Our Ref: LU/334/18/PL
Your Ref:

Town & Country Planning Act 1990 (as amended)
Town and Country Planning (Development Management Procedure) (England) Order 2015
Application for Planning Permission

Development Extension to existing allotment site
Location Worthing Road Allotments Worthing Road Littlehampton

- Planning application boundary
- 4no. 10m x 25m Rod plots
- 8no. 10m x 12m Rod plots
- 2no. 10m x 6m Rod plots
- 1m grass footpath between plots
- Road
- 6 hard surfaced car parking spaces
- Water trough
- Existing fence
- Refer to DWG no. CLA03

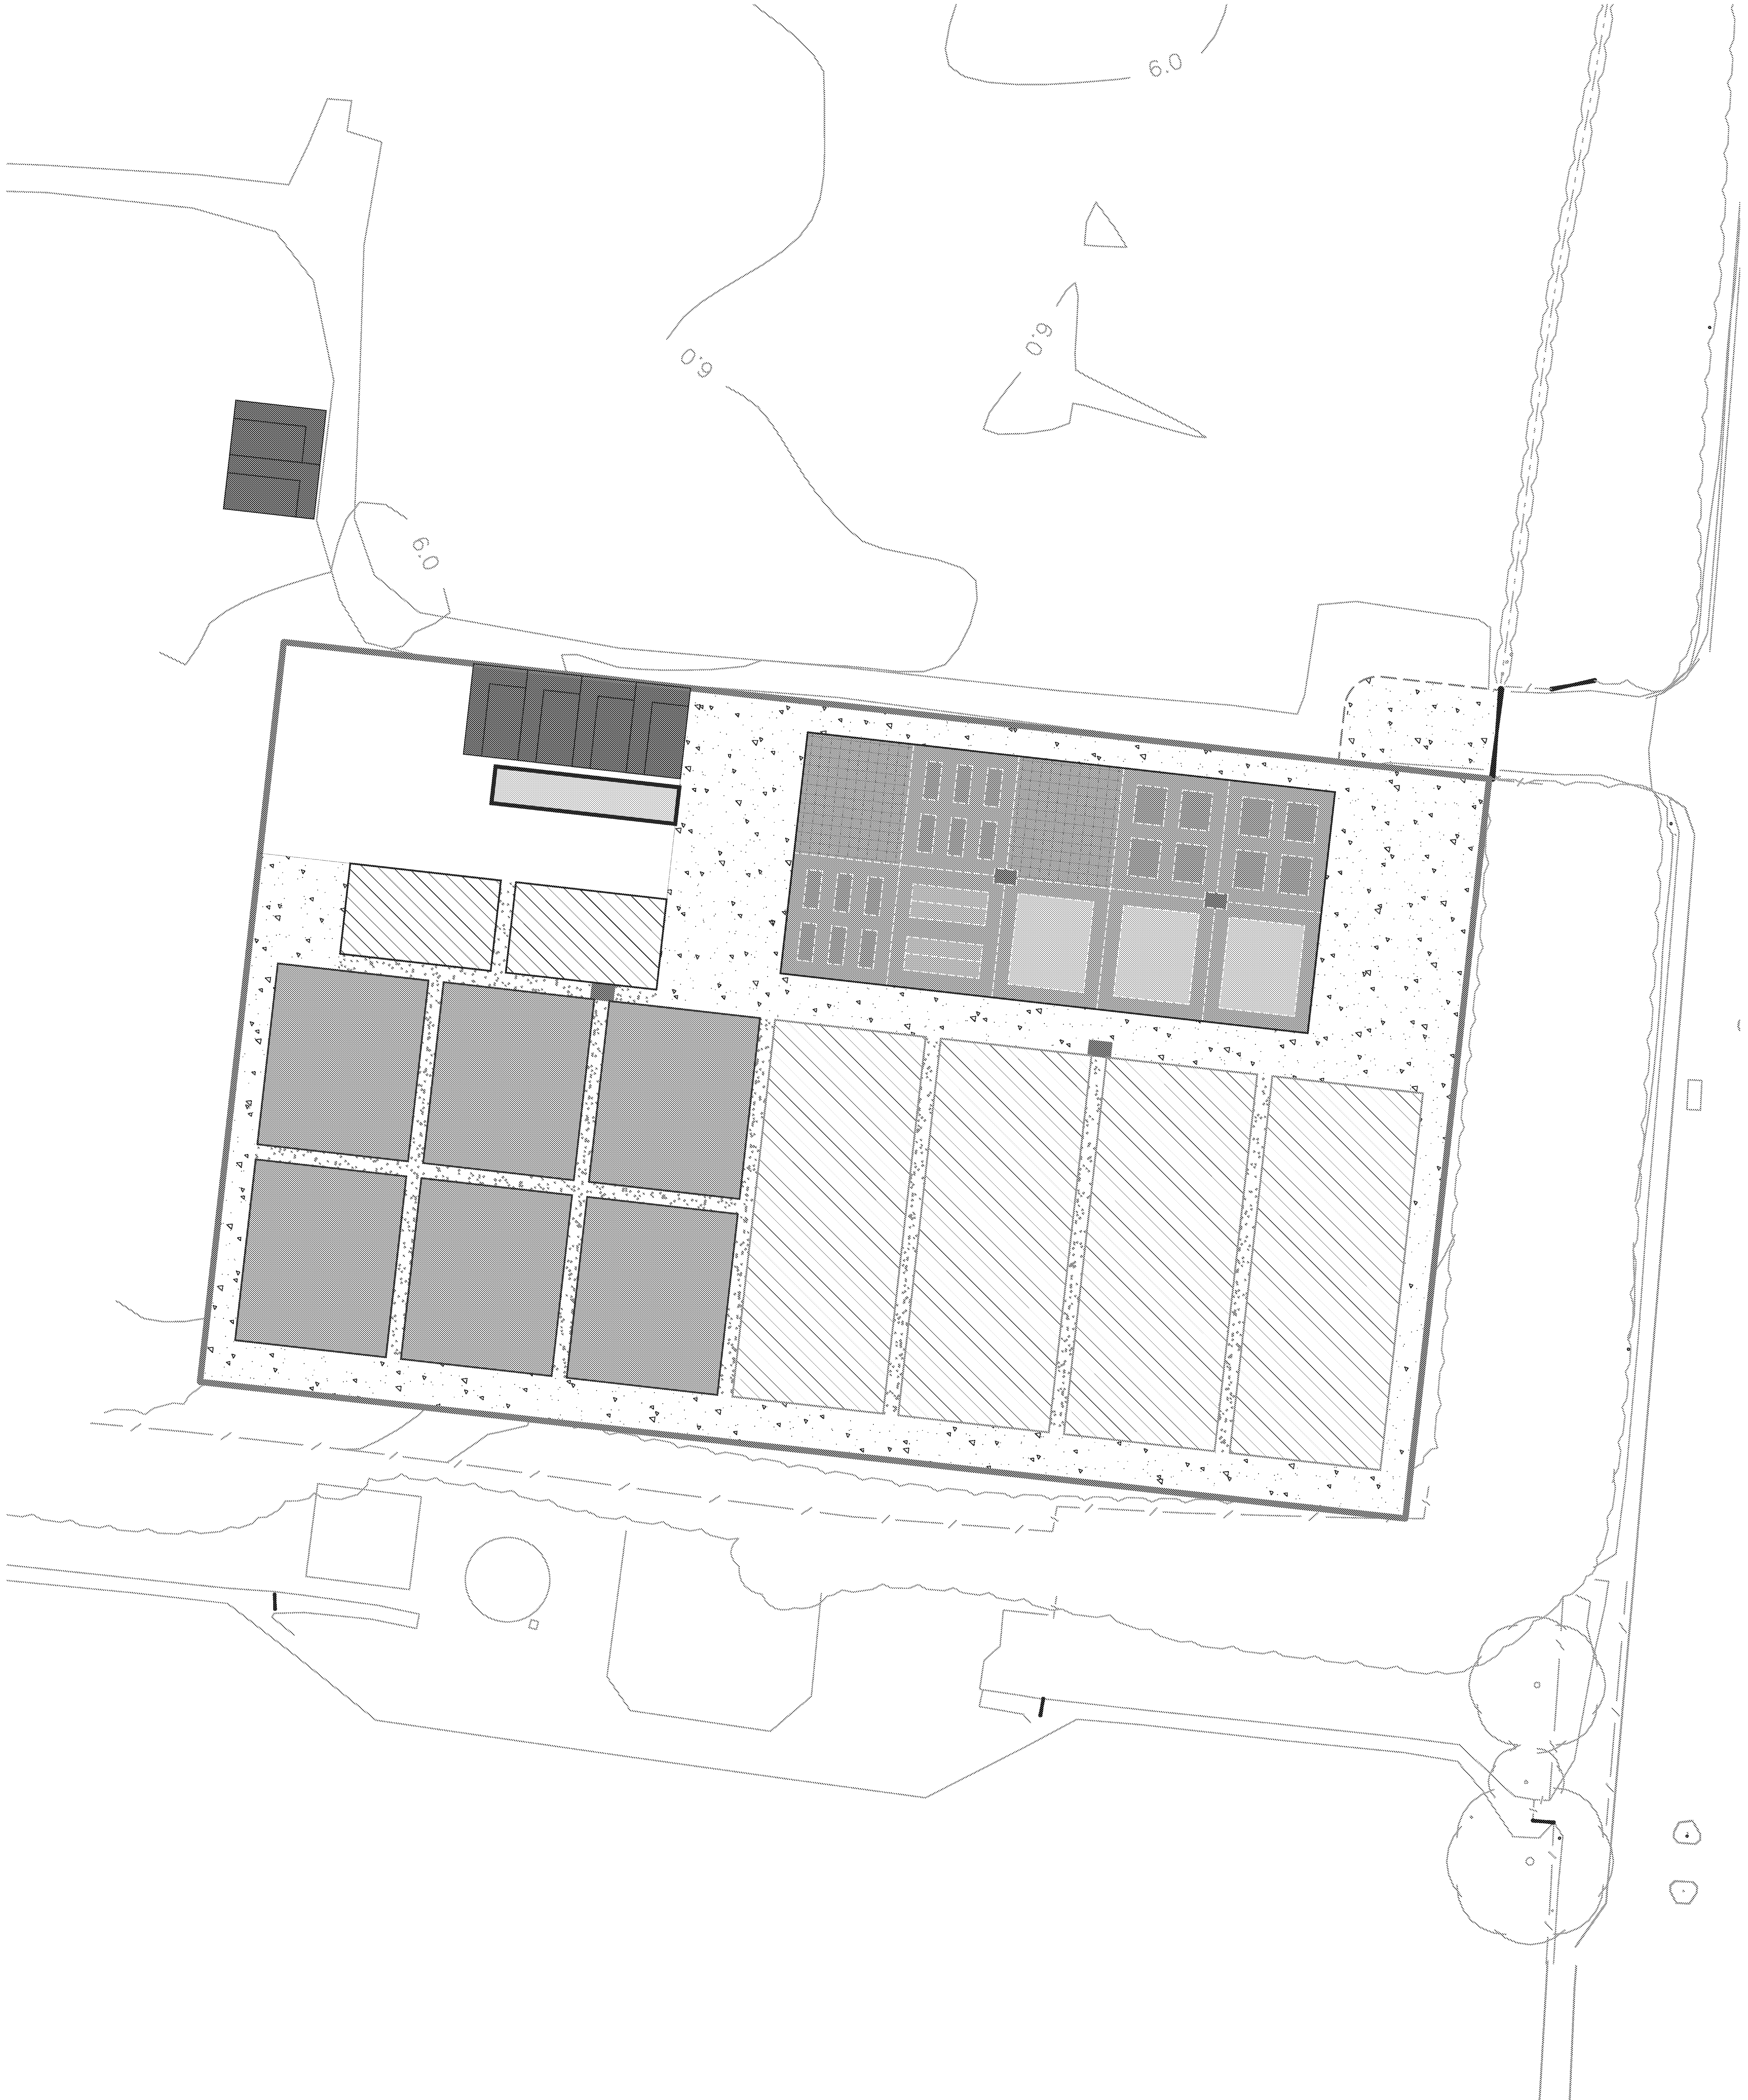
The entrance & additional car parking spaces should form part of the red edged site area. Please forward amended Location & Block plans and further fee should this cause the fee to increase into the next 0.1hec.
